**KIRKLEES METROPOLITAN COUNCIL
INVESTMENT & REGENERATION SERVICE**

DELEGATED DECISION TO DETERMINE PLANNING APPLICATIONS

Reference No:	2022/62/92569/E
Site Address:	3, Near Bank, Shelley, Huddersfield, HD8 8LS
Description:	Extension to existing driveway to create additional off street parking space
Recommending Officer:	Nina Sayers

DECISION – CONDITIONAL FULL PERMISSION

Drawing Name
Existing And Proposed Elevations
And Sections

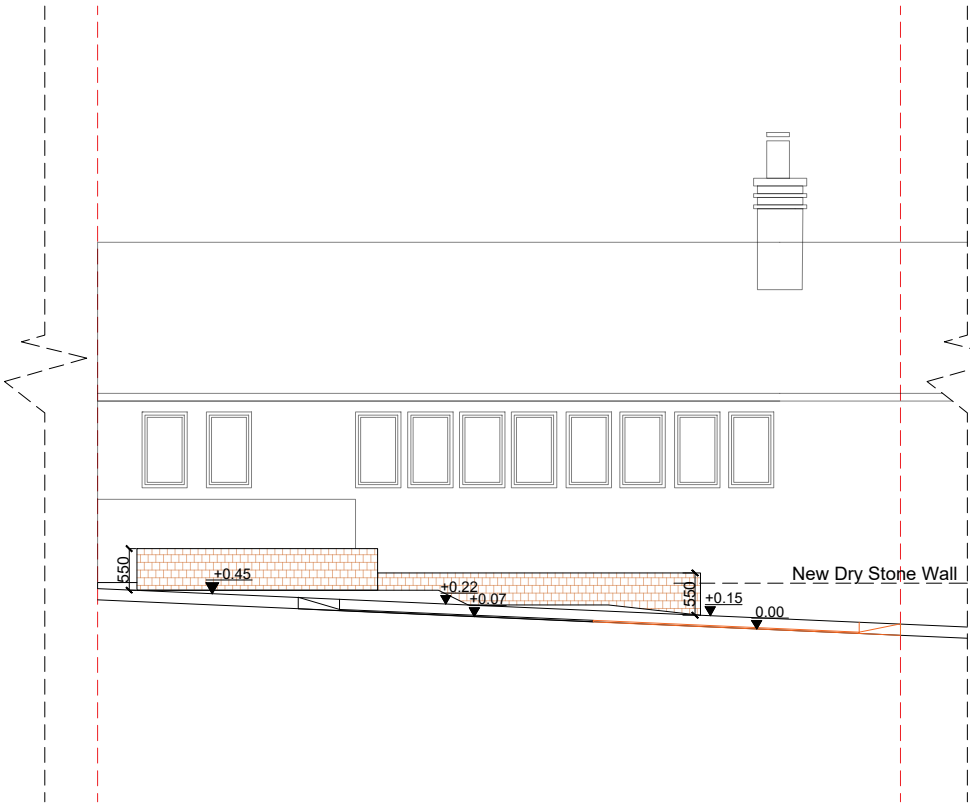
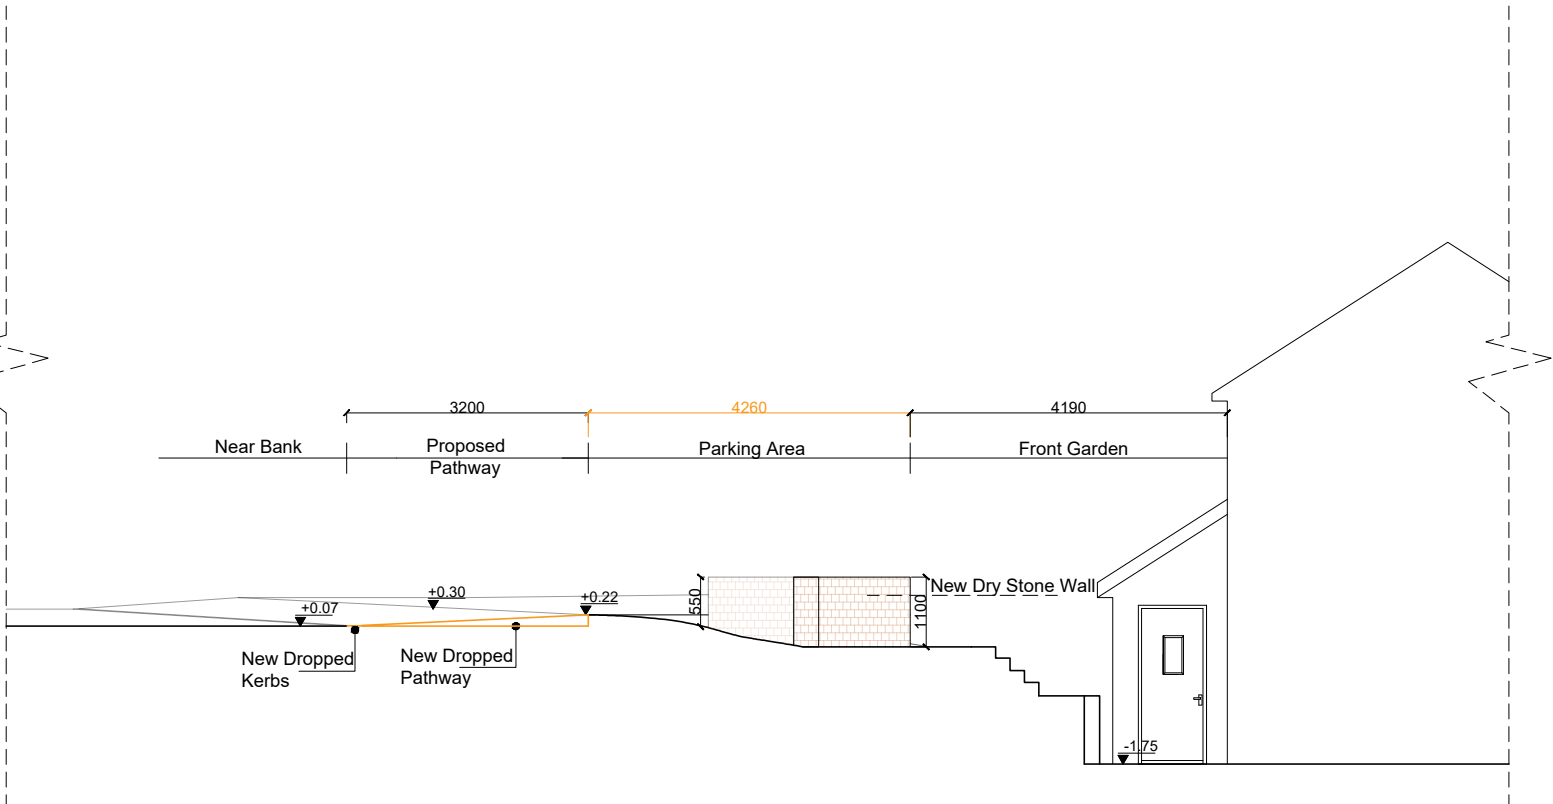
The proposed development would include the extension of the existing retaining wall and the erection of a dry-stone wall. This would result in a structure to the front of the host dwelling which would have a total height of 1.1 metres. Given the set down of the host dwelling, this could potentially result in some additional overshadowing to the openings in the front elevation. It is noted that this would be a relatively small addition in height, and it would be set away from the front elevation of the property. It is also noted that there is already an existing retaining structure to the front of the property. As such it is considered on balance that no significant harm would be caused to the amenity of any future occupiers, over and above the existing arrangement on site.

It is noted that the proposed structure would result in a retaining wall in close proximity to the highway and as such a footnote would be added to any decision to outline the applicants' responsibilities. Whilst not requiring planning permission, the changes to the dropped kerb would require a section 184 agreement, a footnote would also be added detailing this.

NOTE: It is the applicant's responsibility to find out whether the work approved by this planning permission requires written approval from the Highways Structures section for works near or abutting highway and any retaining structures. Contact Highways Structures Section on Tel No. (01484) 225616 who can advise further on this matter.

Drawing Name Proposed Block Plan	
Project Address 3 Near Bank, Shelley, Huddersfield, HD8 8LS	
Scale 1/500 at A3	Date 13.07.2022
Designer DG	Revision V2
Drawing No. 3NearBank_ProposedBlockPlan_V2

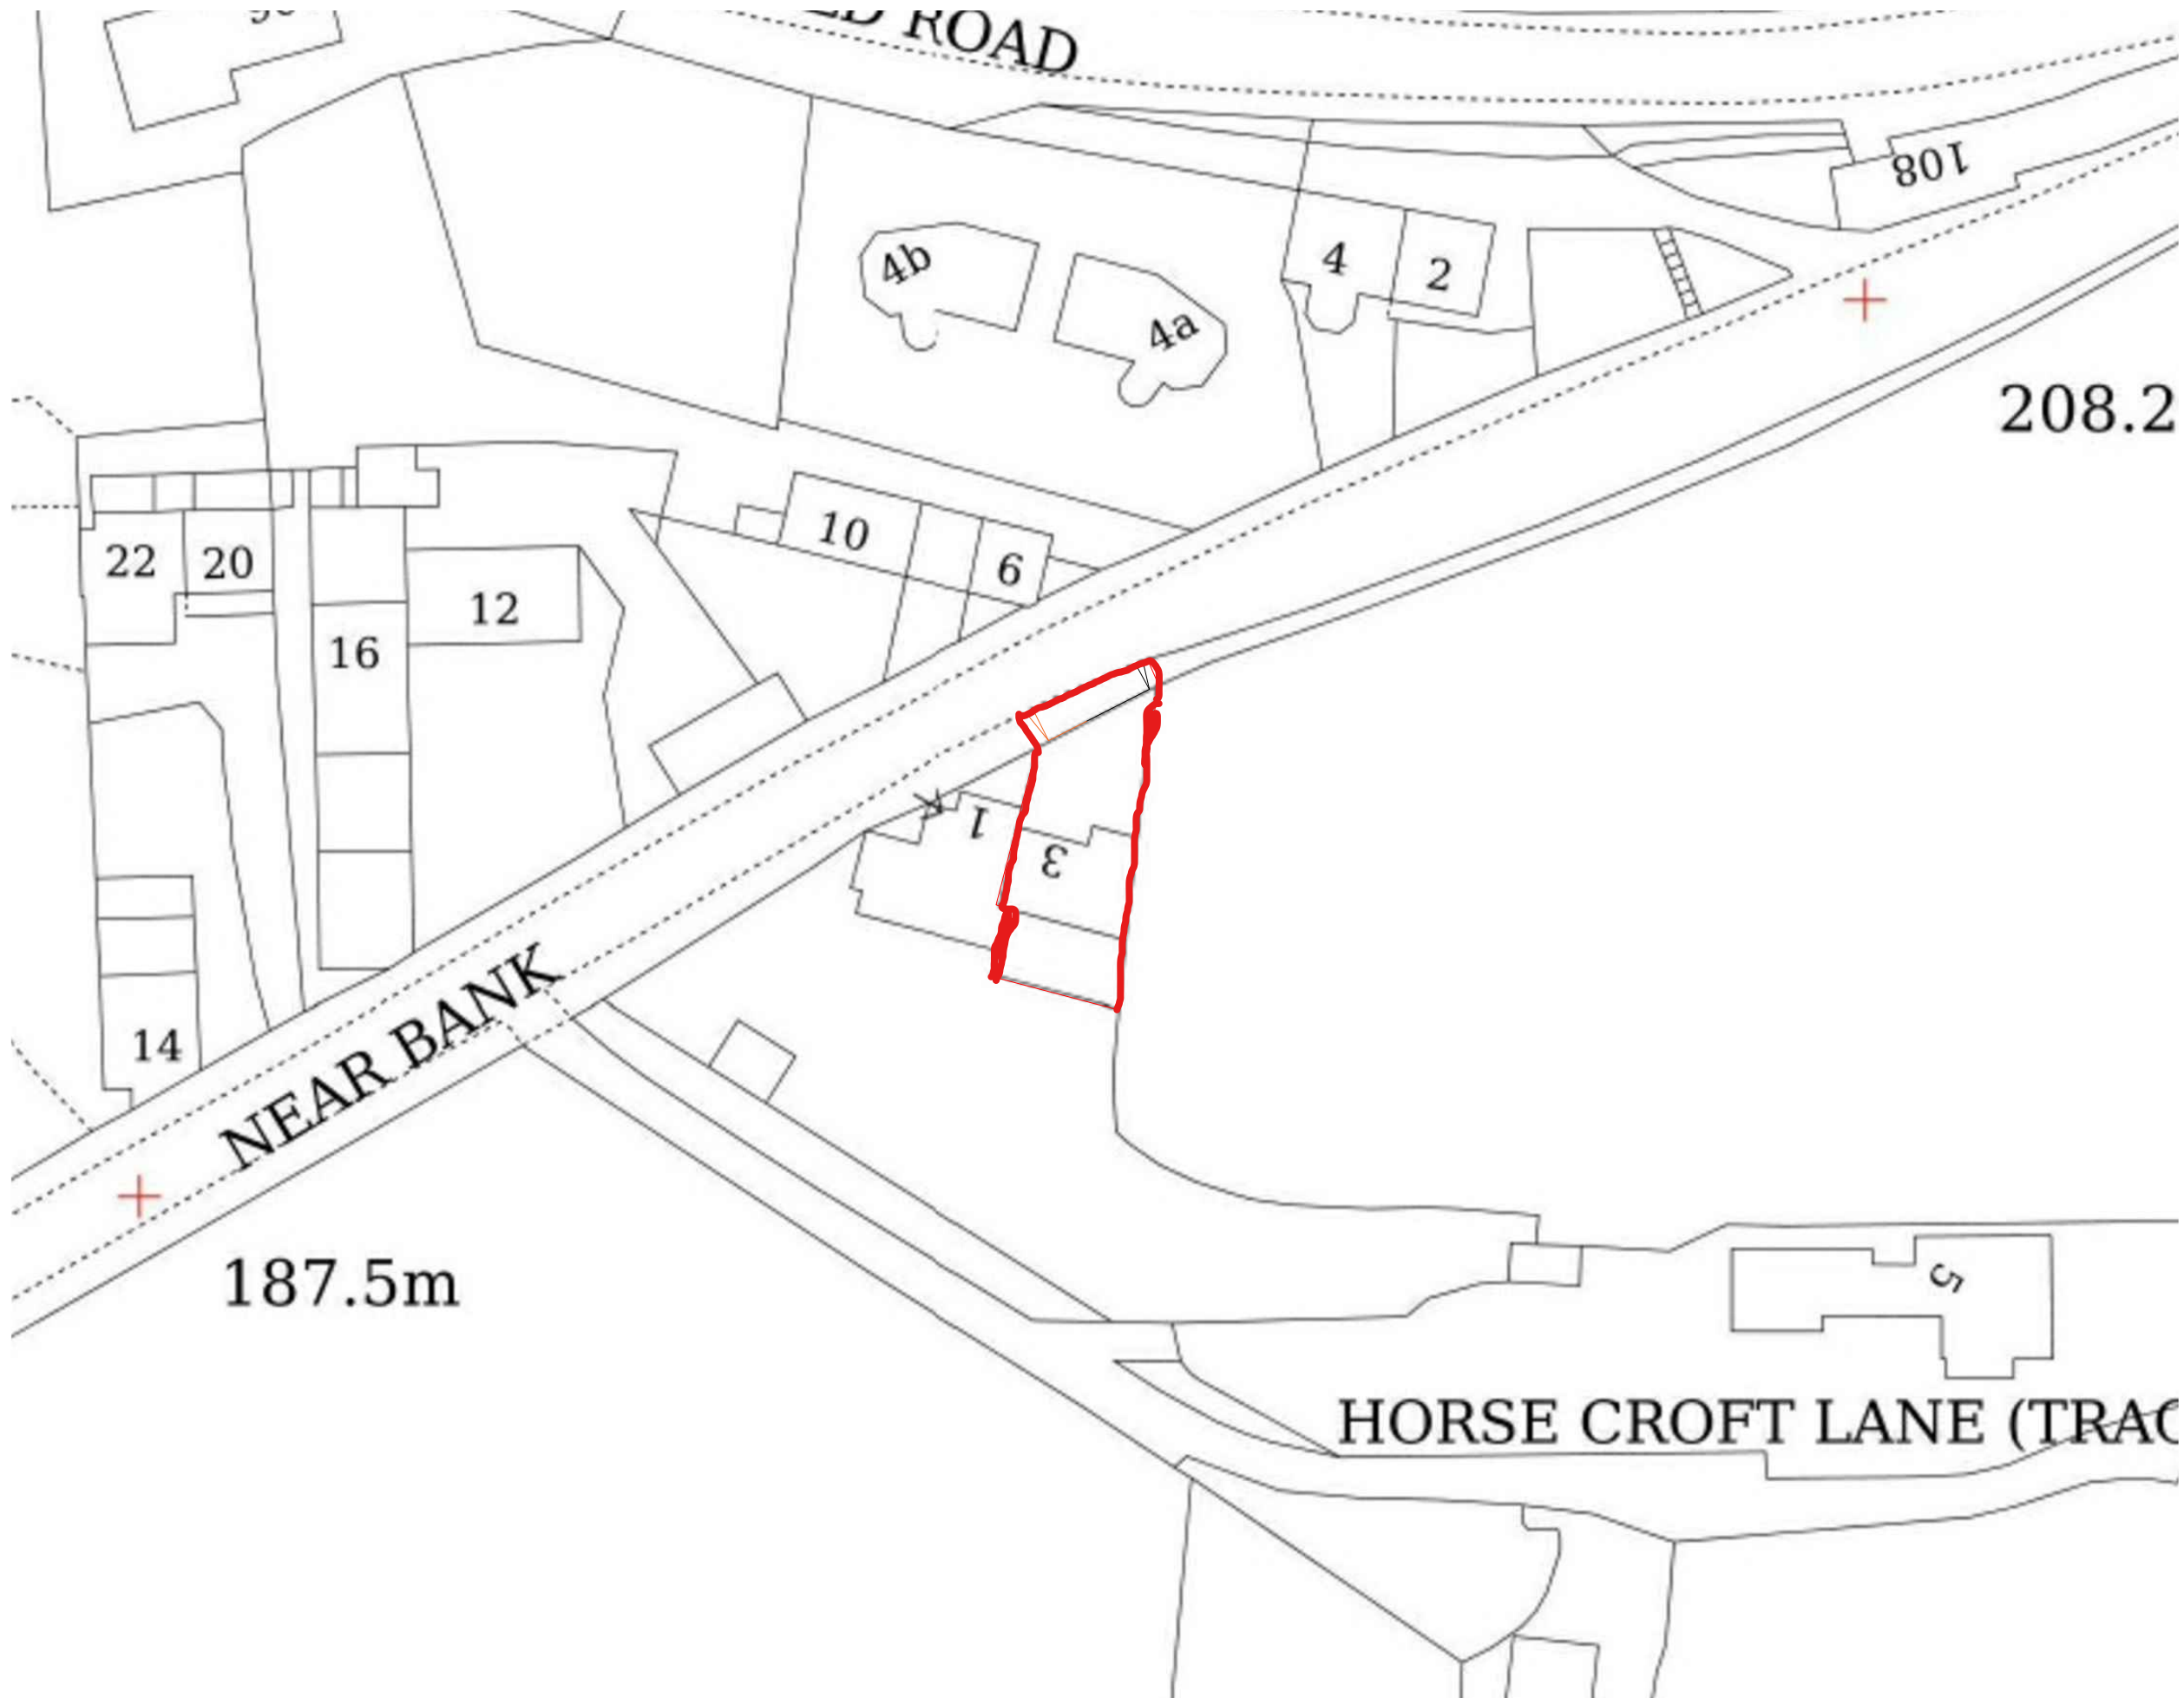
The existing parking area to the front of the dwelling would be extended by a width of 4.2 metres. It would have a total depth of 5.3 metres. It would be finished in Indian Sandstone Paving Slabs.

The proposal would also include the widening of the existing dropped kerb to a total of 8.6 metres. It is noted that Near Bank is not a classified highway and as such planning permission is not required for the dropped kerb.

The proposed development would extend the existing parking provision to the front of the host dwelling and as such the precedent for hard landscaping has already been determined. It is noted that the properties opposite the application site have hardstanding for vehicle access and as such the addition of hardstanding would not be out of character with the surrounding area.

It is noted that some of the existing garden area would be lost to the proposed parking provision. From a visual amenity perspective, this is considered to not cause significant harm as the existing garden is set down at a lower elevation to the highway and as such does not shape the character of the front of the property when viewed from the highway.

The proposed development would widened the existing parking area to the front of the dwelling. KC Highways DM were consulted regarding this proposal and they outlined that whilst it is acknowledged that the depth of the bays is not to the prescribed standard, the double bay would be so wide as to almost be able to accommodate two vehicles parked parallel to the highway. It therefore seems reasonable to expect two cars to be able to park without obstruction the existing footway on Near Bank.

Details of the surfacing and drainage of the proposed parking area would be conditioned.

3. Before the development is first brought into use, the approved vehicle parking areas shall be surfaced and drained in accordance with the Communities and Local Government; and Environment Agencies 'Guidance on the permeable surfacing of front gardens (parking areas)' published 13th May 2009 (ISBN 9781409804864) as amended or superseded; and thereafter retained throughout the lifetime of the development.
